From: [Rael, Rudy E.](#)
To: ["Mike Walla \(mikew@wallaengineering.com\)"](mailto:mikew@wallaengineering.com)
Subject: Animal Humane Society
Date: Friday, September 23, 2016 12:30:00 PM

Based upon the information provided in your submittal received 9/2/16, the above referenced Grading and Drainage Report and plan cannot be approved for Grading Permit or Building Permit until the following comments are addressed:

C1.1

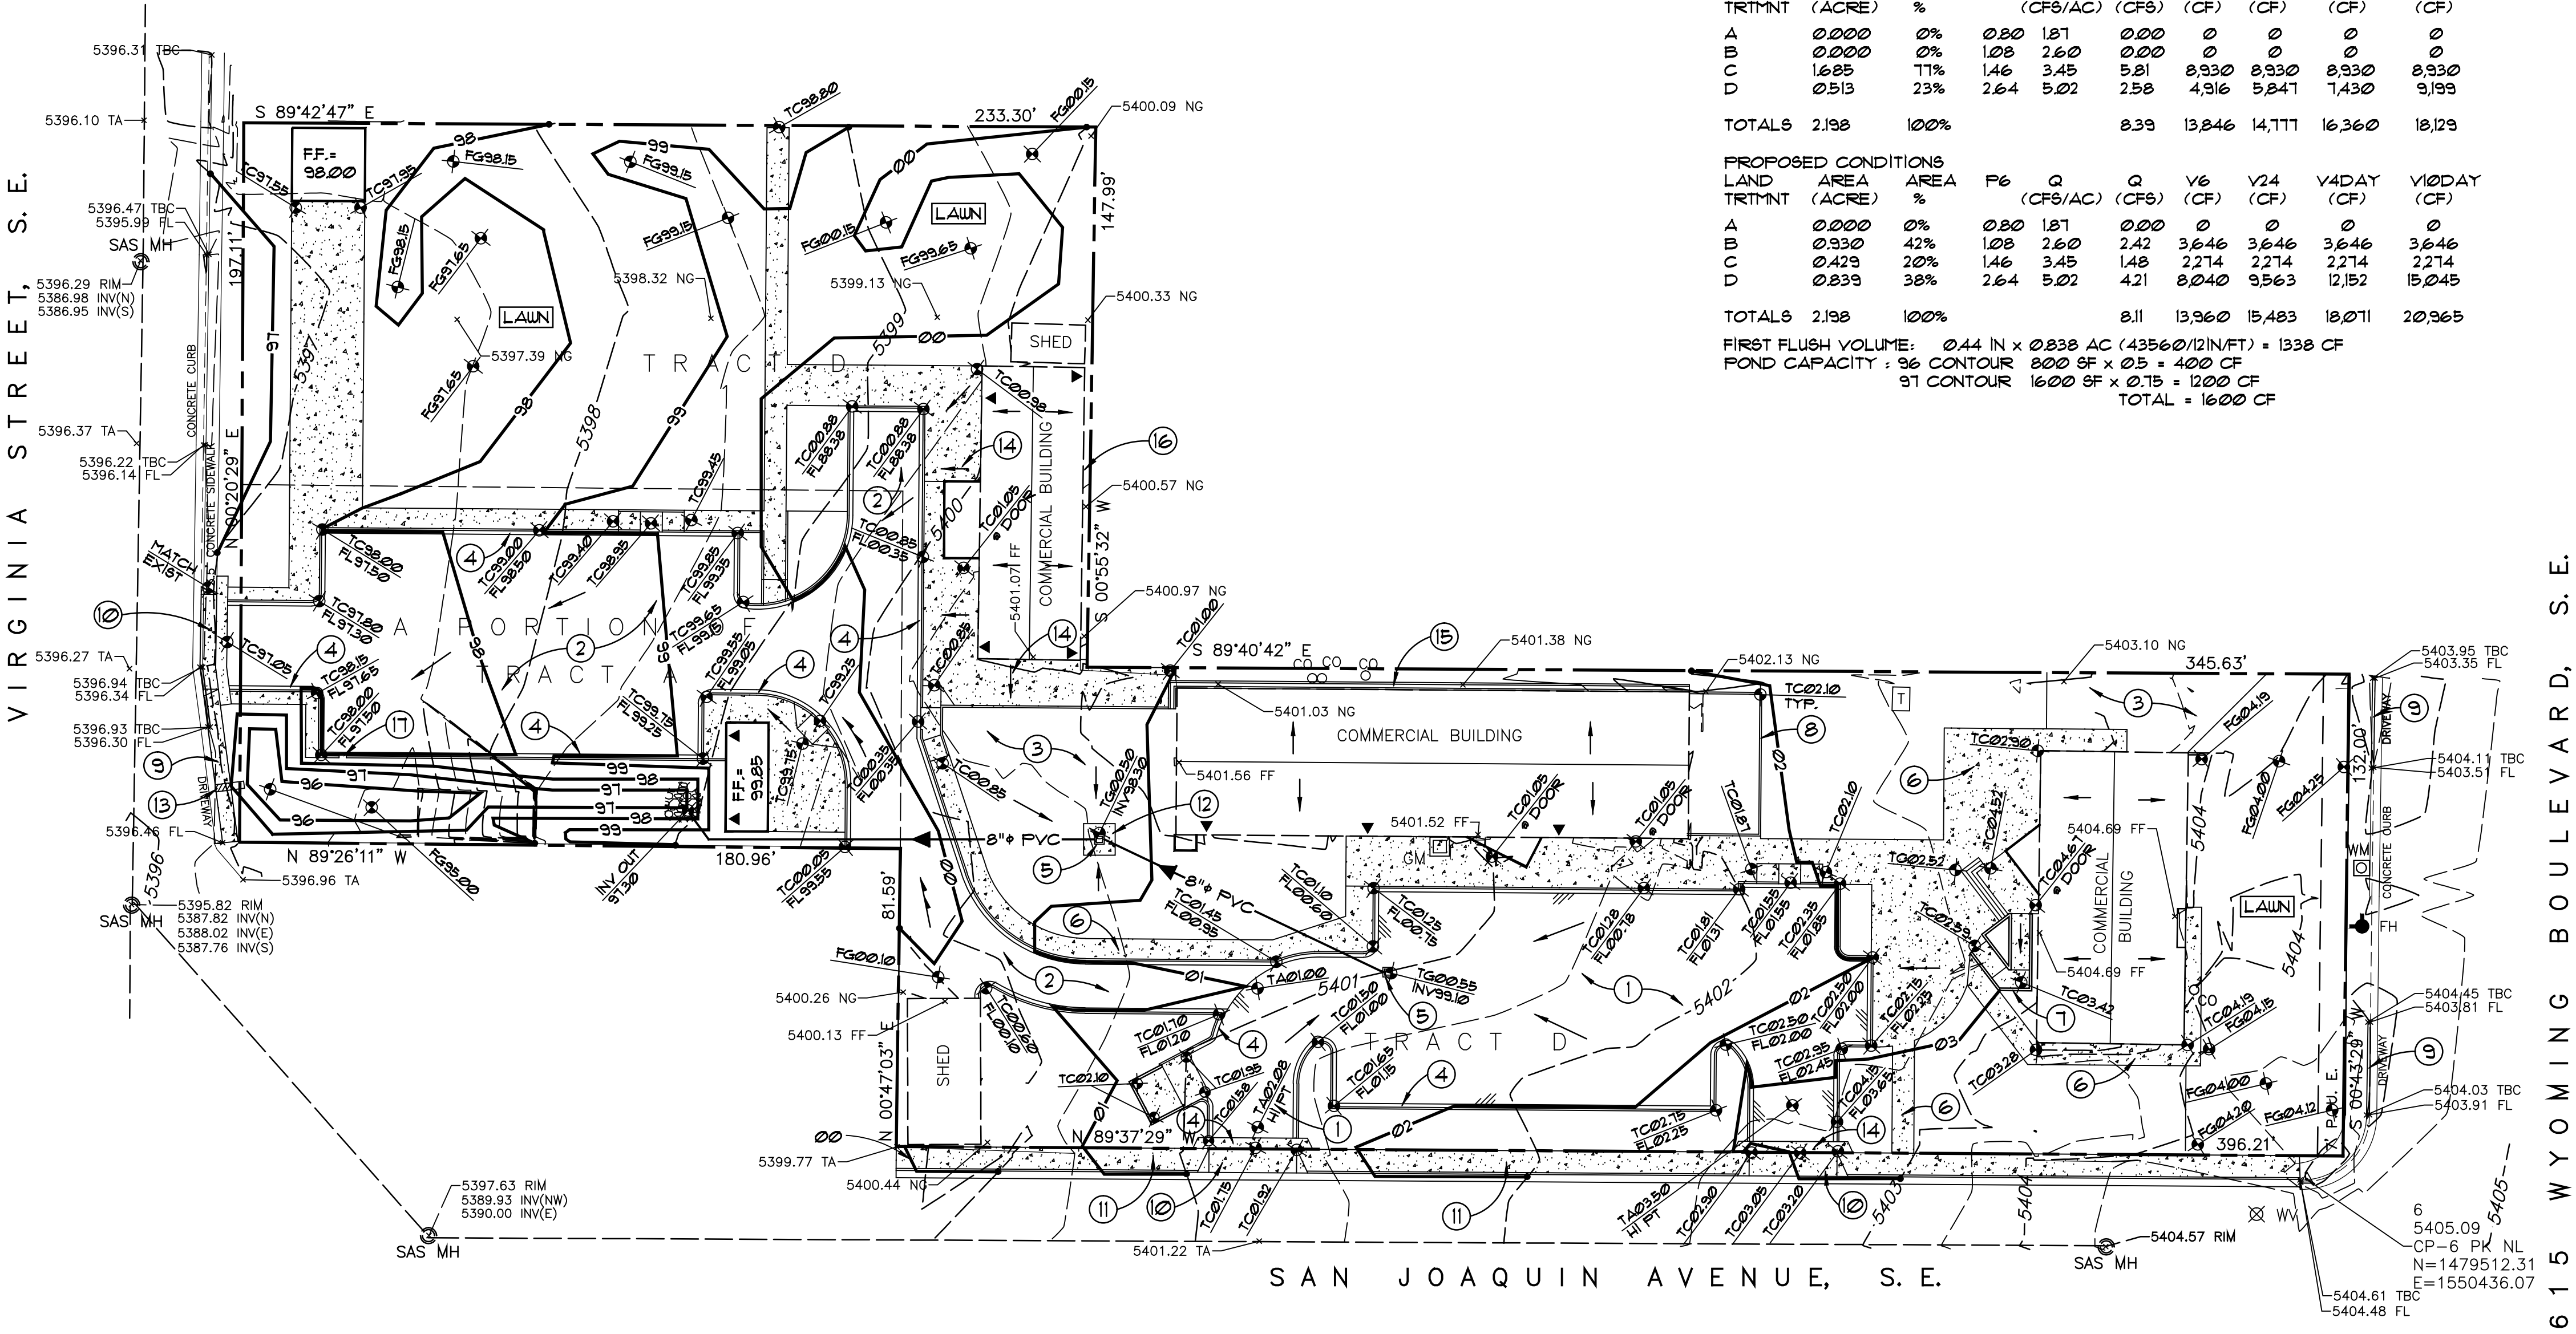
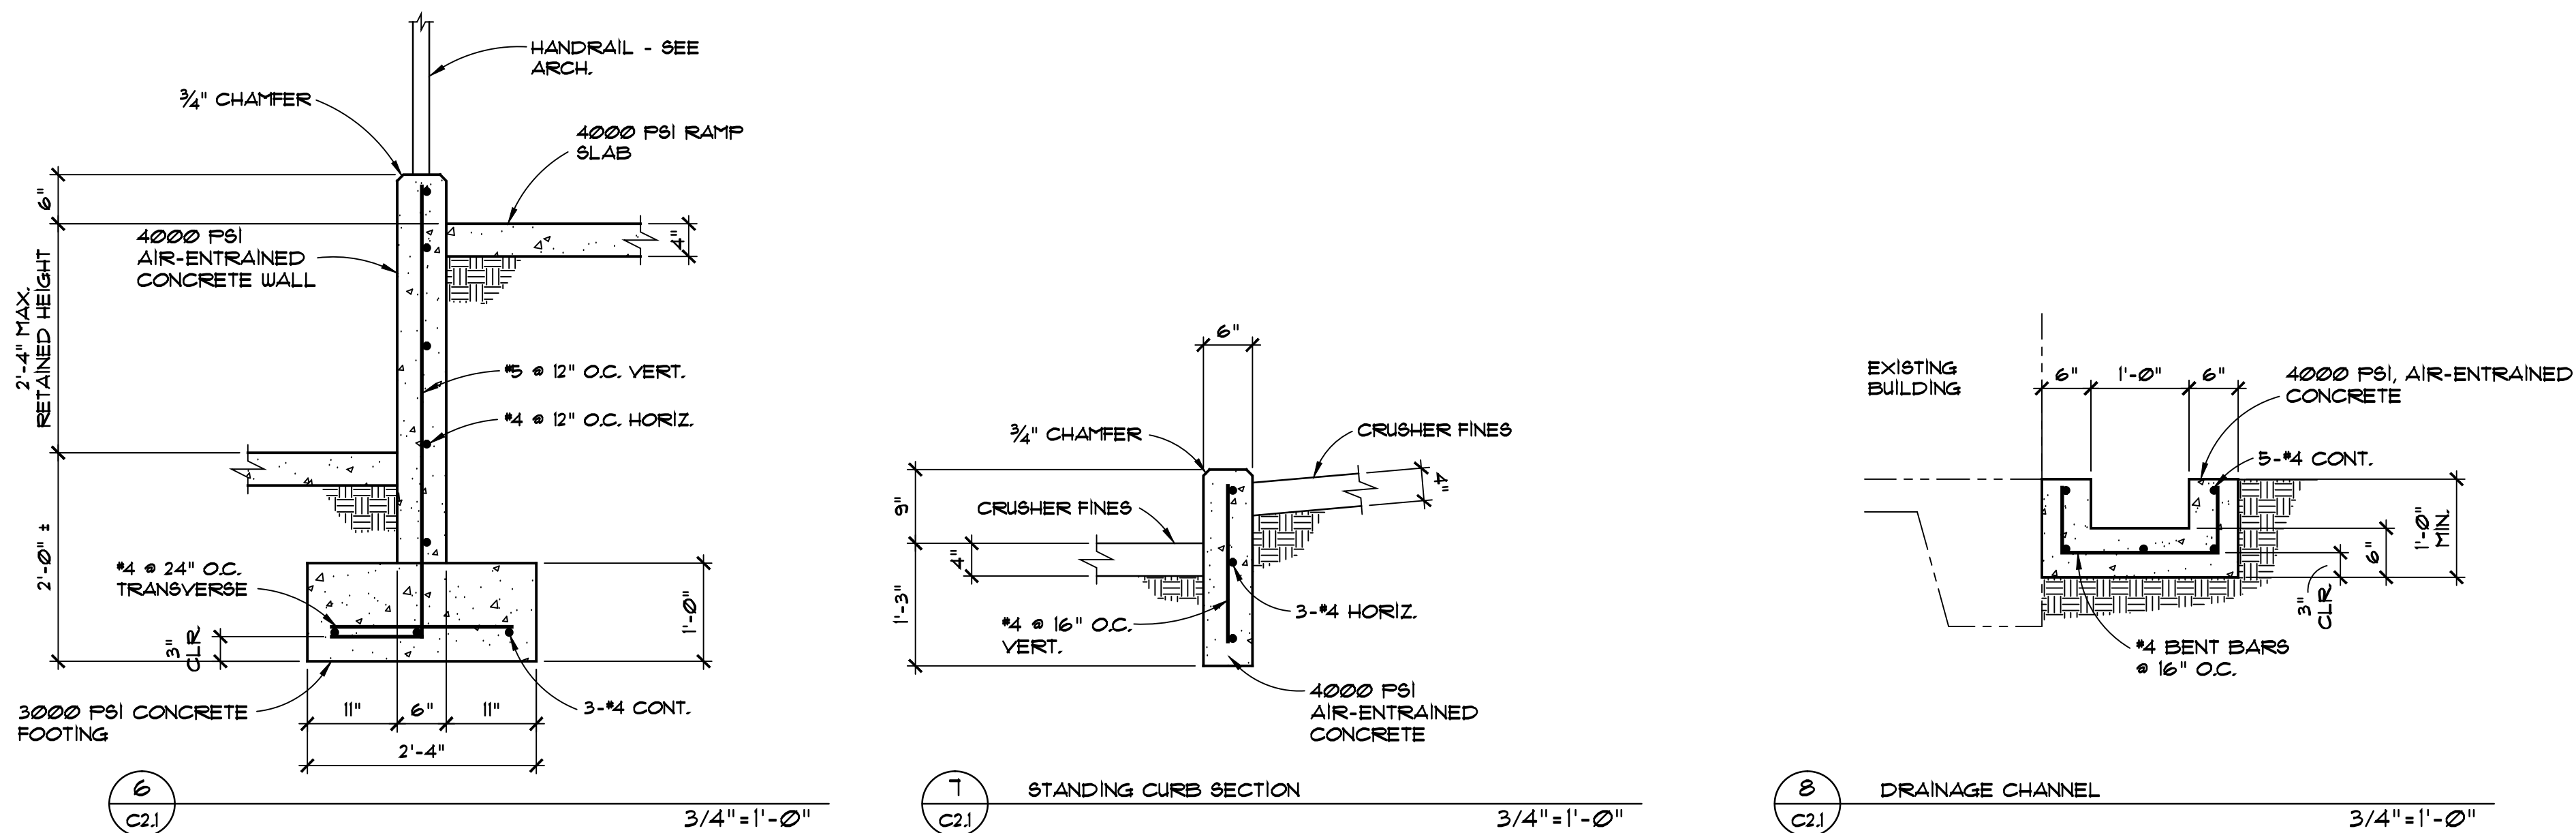
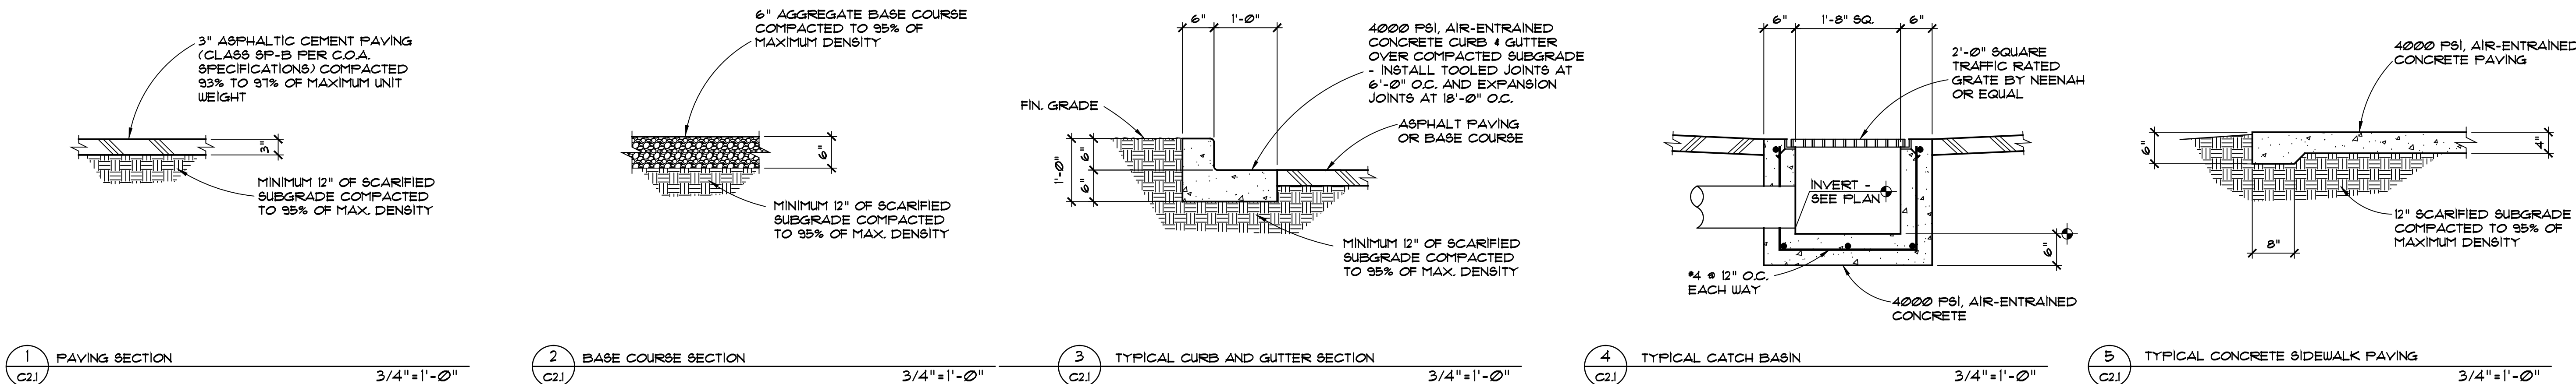
- Provide the roof flows. How will the flows navigate around the buildings?
- Provide SO-19 notes for the side walk culvert. Extend the side walk culvert 1' passed the property line.
- Show how off-site flows will be diverted around this site.
- Show how flows will not enter the SFD to the SW corner.
- Provide a curb cut opening near the driveway entrance. Slope the parking area toward the curb cut opening at FL 97.90.
- Depress all landscape areas.
- Provide an Erosion and sediment control plan or the permit if provided by another engineer.
- Provide how vehicles will navigate around the property at the SW corner of this site, there does not appear to be enough room for a double lane. Are the owners giving permission or are they allowing the animal humane society to cut through the corner of their property? Provide the written document allowing this access.
